**APPLICATION BY THE DROVES SOLAR FARM LIMITED FOR AN ORDER
GRANTING DEVELOPMENT CONSENT FOR THE DROVES SOLAR FARM**

APPLICATION REF: EN0110013

**WRITTEN REPRESENTATION OF THE HISTORIC BUILDINGS AND
MONUMENTS COMMISSION FOR ENGLAND (HISTORIC ENGLAND)**

## 2.9 Statutory Historic Environmental Features Plan

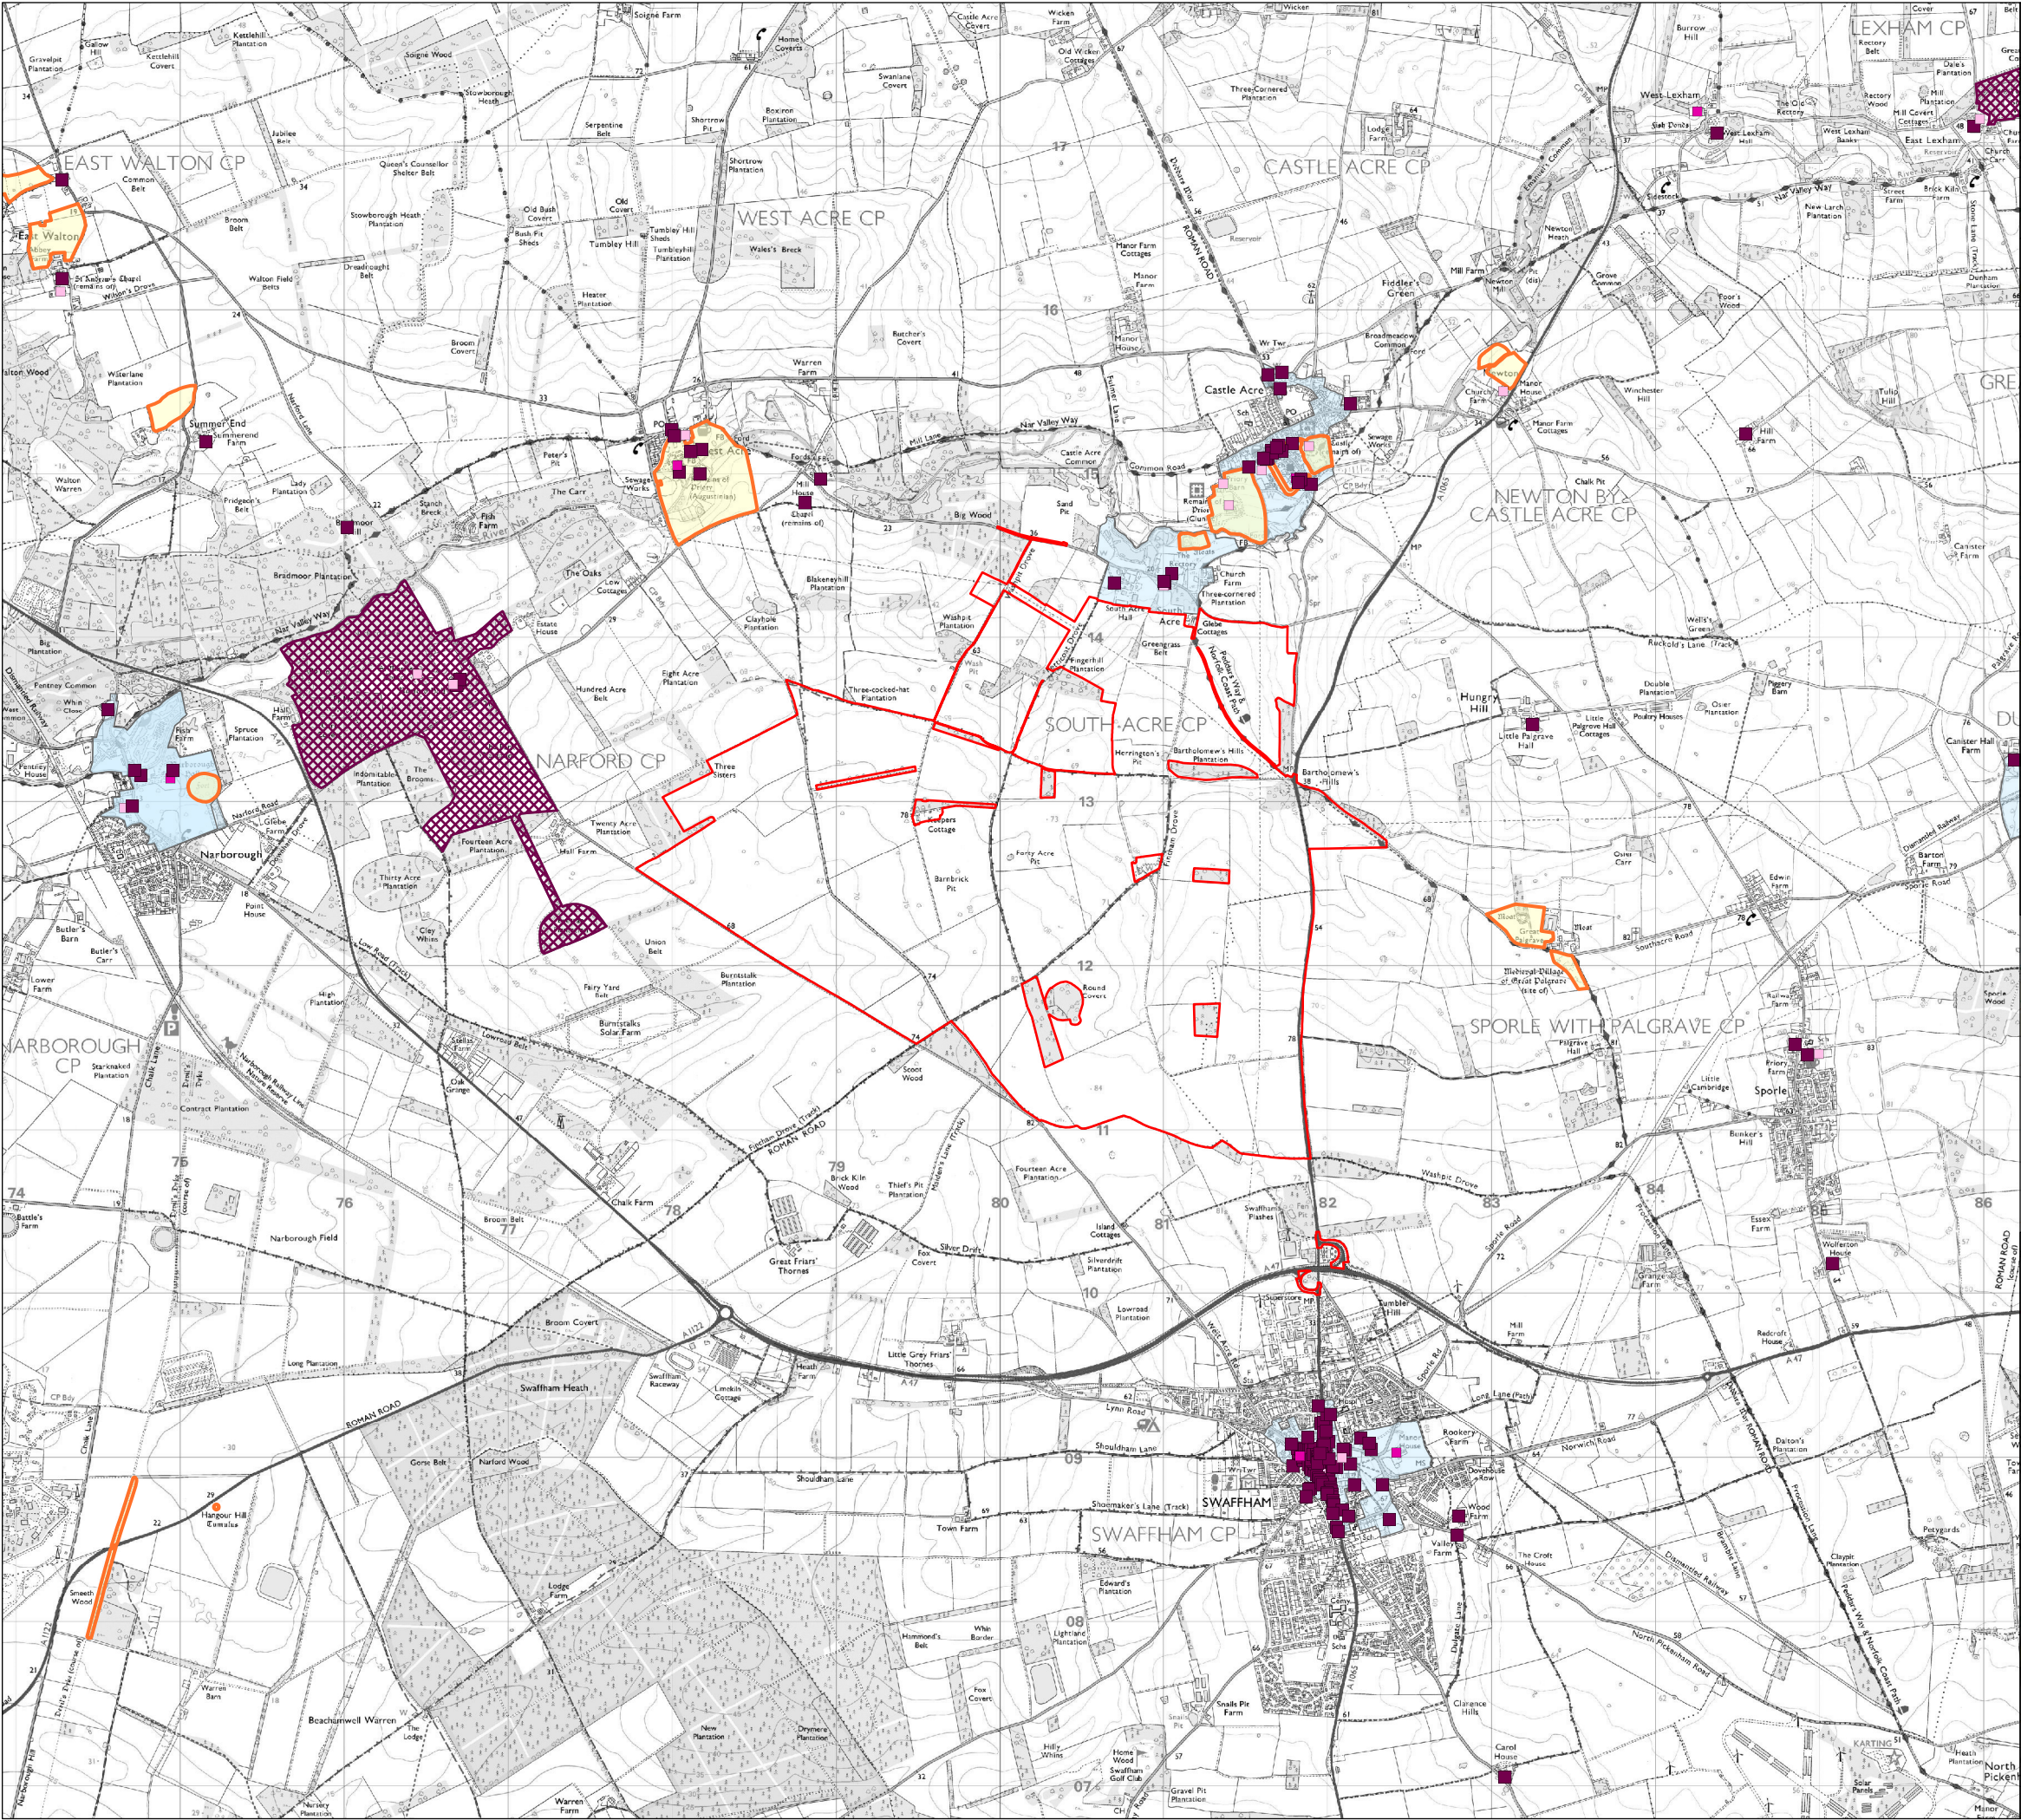
- 2.1 The information relevant to the historic environment assessment is found primarily in the following documents:
- Statutory Historic Environment Features Plan [APP-015]

- 2.2 Our primary consideration is the impact of the proposal on the significance of highly designated heritage assets comprising scheduled monuments, grade I and grade II* listed buildings, and conservation areas. As set out above, the focus of our advice is on the highly designated heritage assets at Castle Acre.
